Council Reference: DA07/0589 LN45515  
Your Reference: MP06\_0243

28 June 2010

**75W Request to Modify Development Consent MP06\_0243  
(DA07/0589) - Major Project 157 lot residential subdivision at  
Lot 2 DP 1000385; Lot 9 DP 1039569 Fraser Drive Tweed  
Heads South**

A.1 Proposed Subdivision Layout

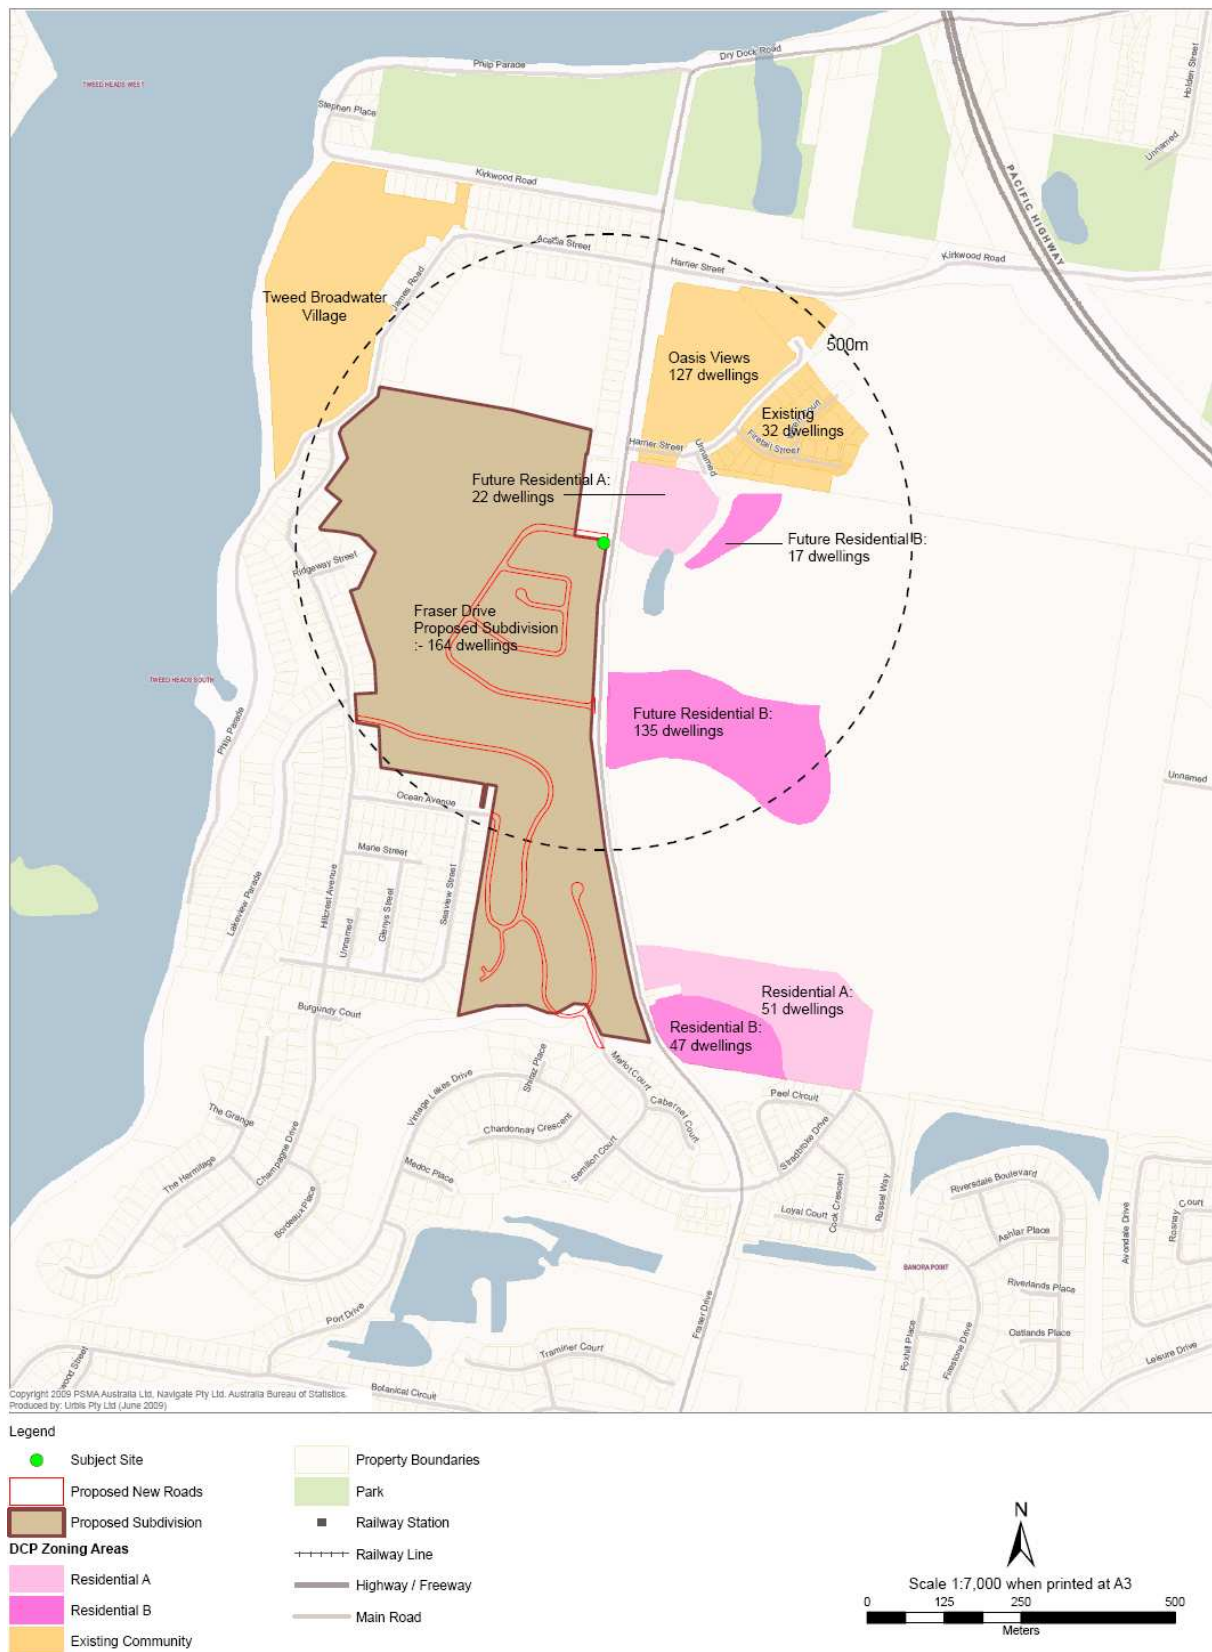
The revised subdivision layout provides an L-shaped Lot 2 at the main entrance to the subdivision. It is considered that this lot has potential to be significantly constrained in terms of road access and servicing, due to its proximity to the Fraser Dr intersection, which is required to be signalised. The proponent has not adequately justified that the location and configuration of this lot is suitable for a local store in this regard. As such, future development applications for the site may not be able to be approved by Council.

A Retail Analysis has been provided in Annexure E. A critical assumption for the site is that it has road access from Fraser Drive. Direct access to Fraser Drive cannot be supported by Council in the absence of a traffic study for the store development. The report refers to "right in/right out" access, which does not make sense, and may have meant "left in/left out". Regardless, unless the proponent can support the location of the store with a traffic report that addresses access and servicing arrangements, including traffic generation and impacts on the surrounding road network, the site of the local store cannot be supported by Council.

ROAD TRAFFIC NOISE ACOUSTIC BARRIER LEGEND

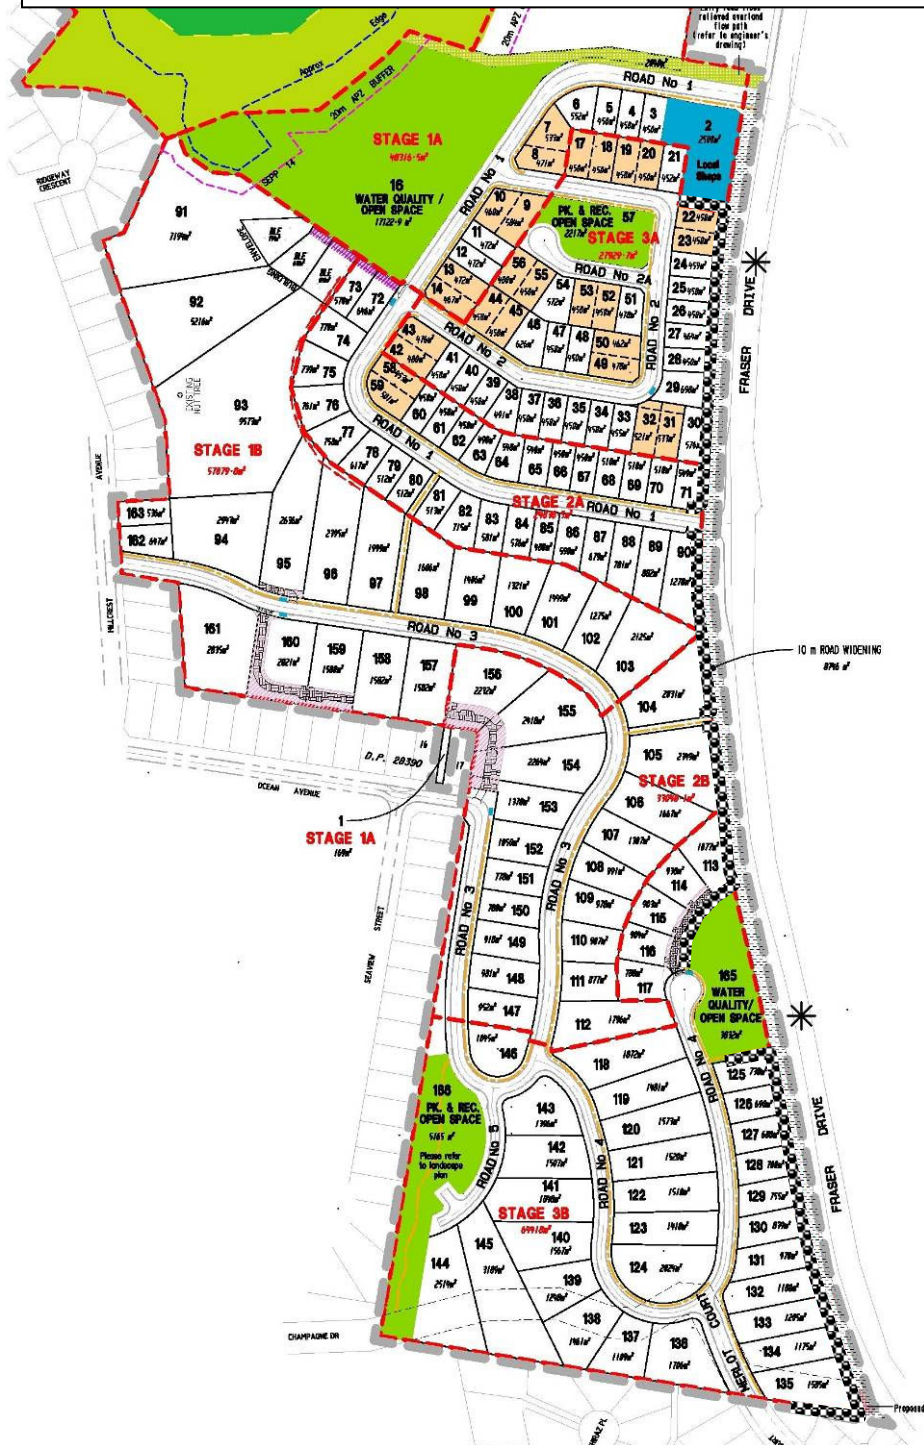
The applicants reasoning to use a balanced acoustic treatment outcome to mitigate potential noise impacts is supported. The use of 3.3m – 7.0m high acoustic barriers alone would detract from the amenity of the area and would not be consistent with the existing built environment of the locality. Furthermore such barriers would themselves create other adverse amenity impacts such as overshadowing.

A combination of a 2.0m high acoustic barrier with the recommended building sound shell treatments and external open space orientations is supported for affected residential development as are the recommended acoustic treatments for the on-site commercial area.

It is recommended that consideration should be given to ensuring the acoustic fence is of a high quality design and incorporates mounding and landscaping to reduce visual impacts.

4.1 Amended Subdivision Layout Plan

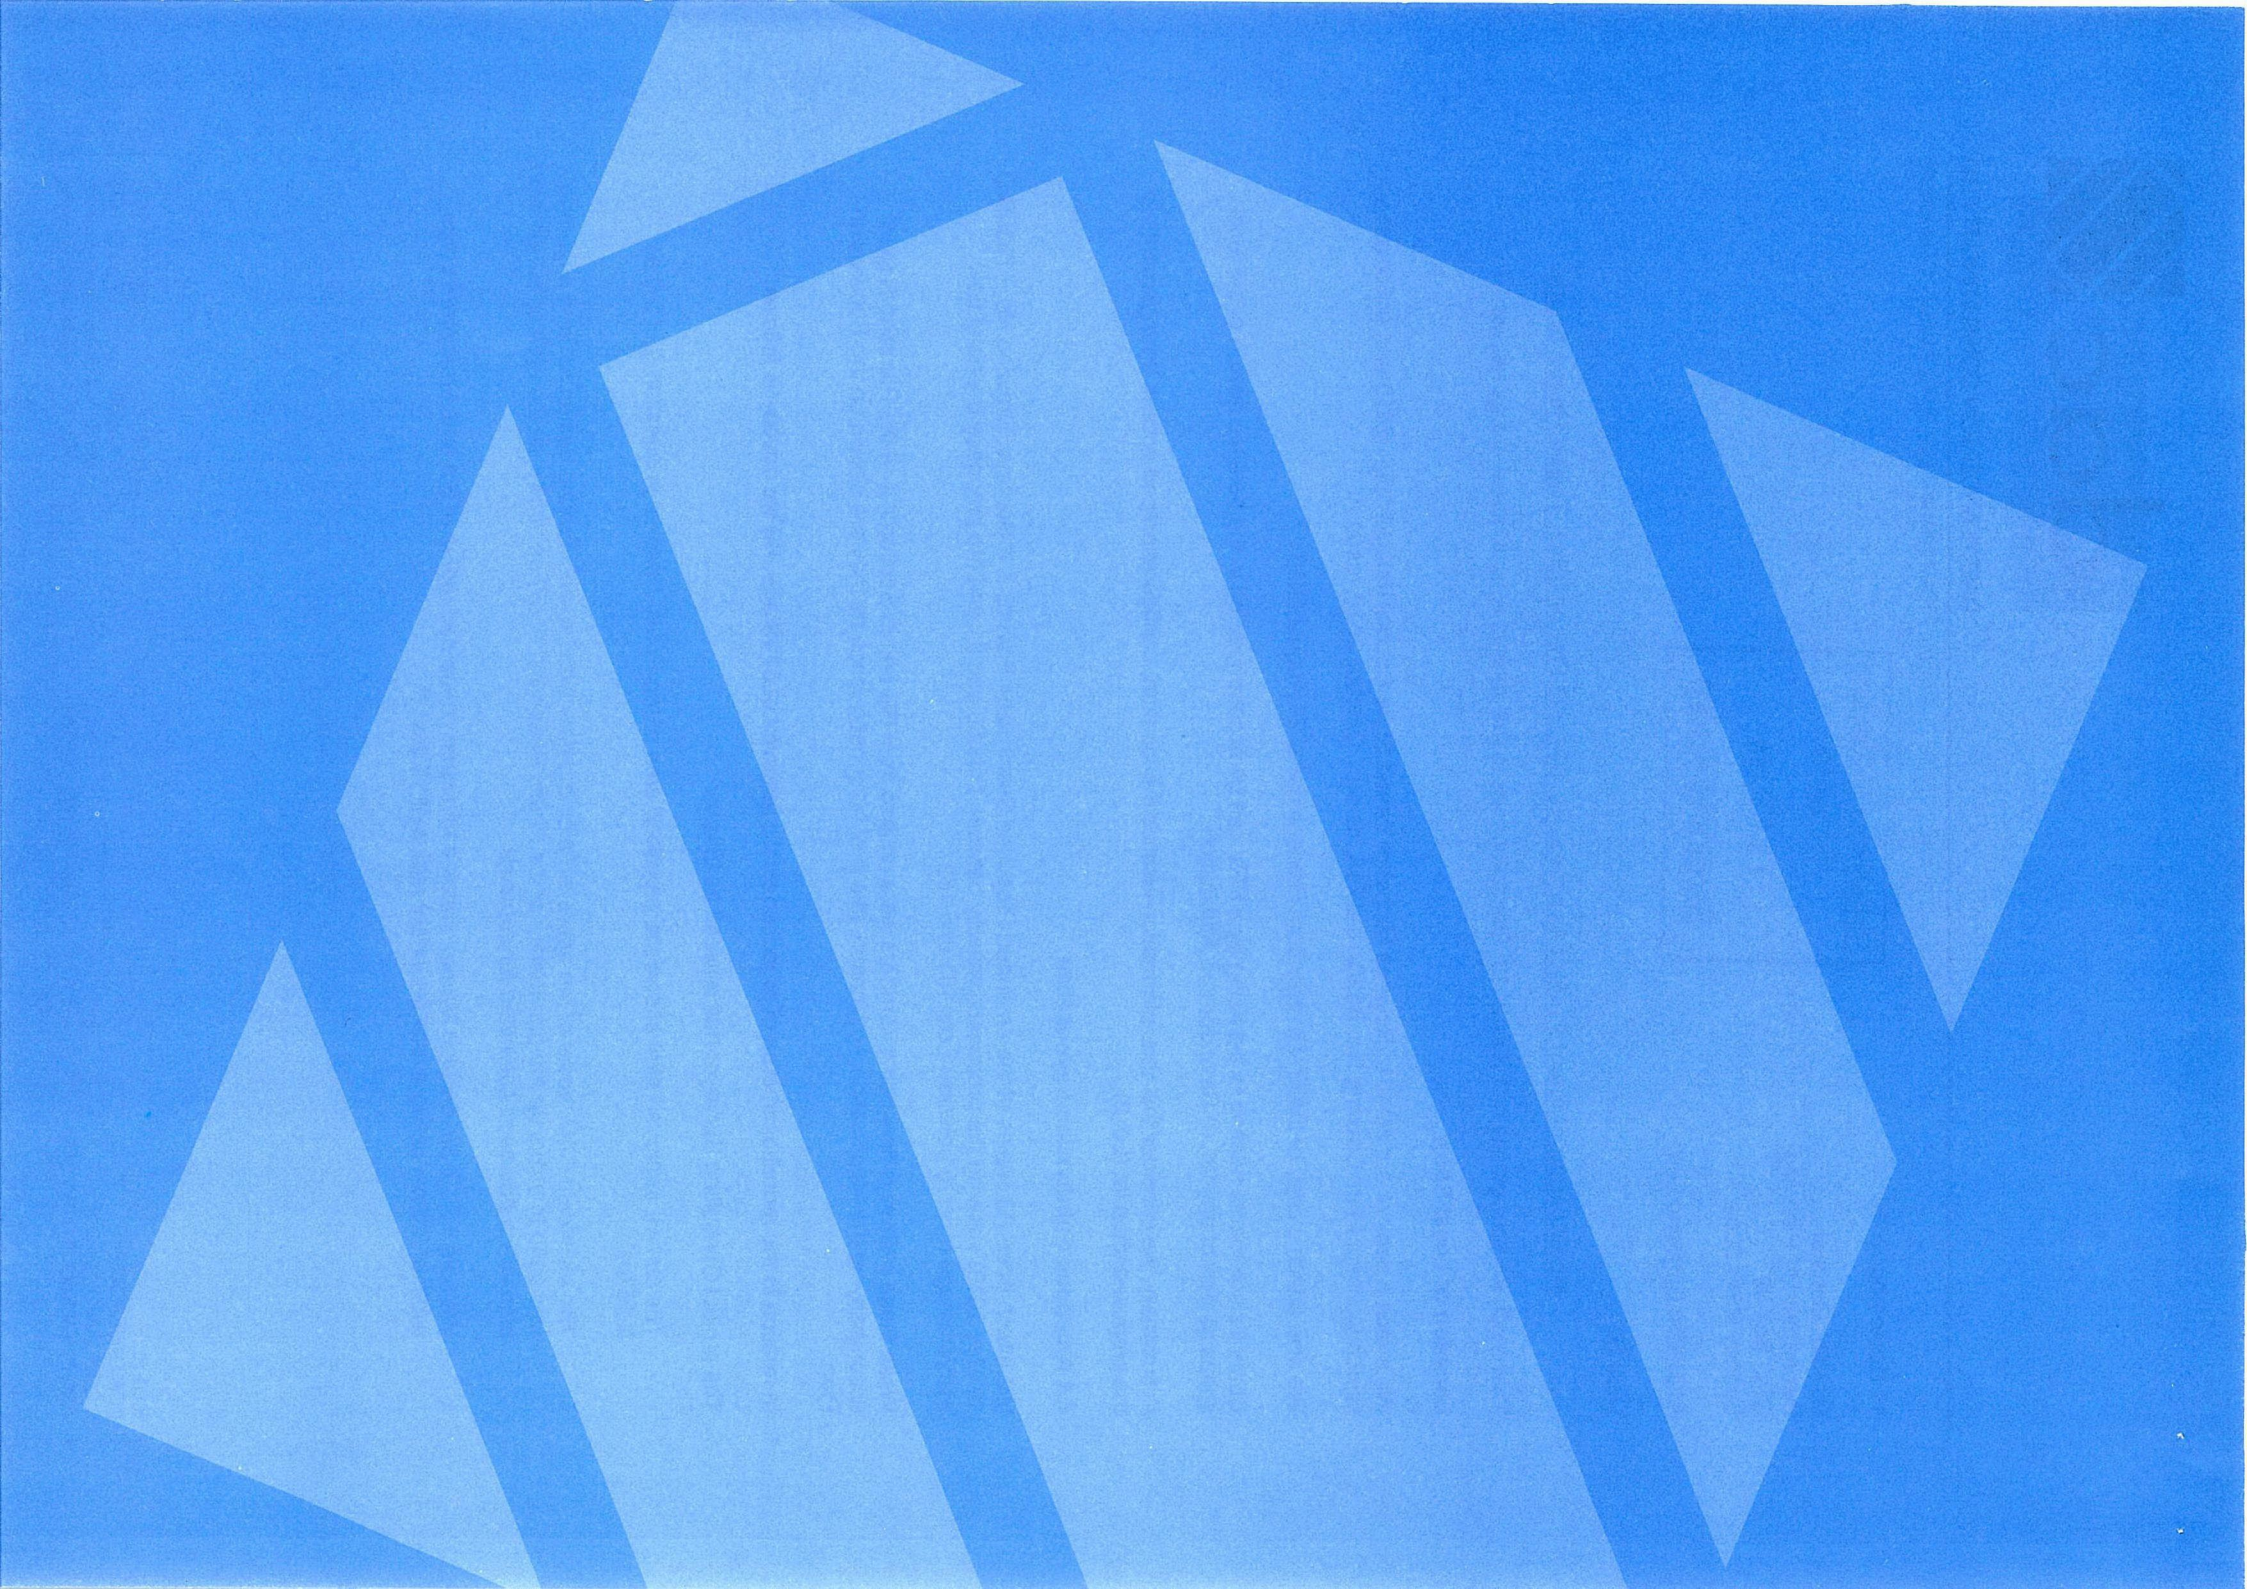
Notwithstanding, there is concern with the reduced size of park identified as Lot 57.

The proposed size of this park is significantly less than the minimum size specified by Tweed Shire Council. Recreation Services previous advice was in a review of the subdivision layout in the amended preferred project report submitted 3 September 2008. In this layout, the size of the park was given as 2,471m<sup>2</sup>. Council's comment at the time was we were prepared to accept an area 30m<sup>2</sup> less than the minimum.

However, somehow approval appears to have been given to a park that is 233m<sup>2</sup> smaller than Council's minimum park size. The latest application to modify the park proposes a further reduction of 50m<sup>2</sup>.

The progressive shrinking of the park to well below the minimum size is undesirable and accordingly this proposal is not supported. Clarification is sought as to how the approval was previously given to a park that is 233m<sup>2</sup> smaller than Council's requirements.
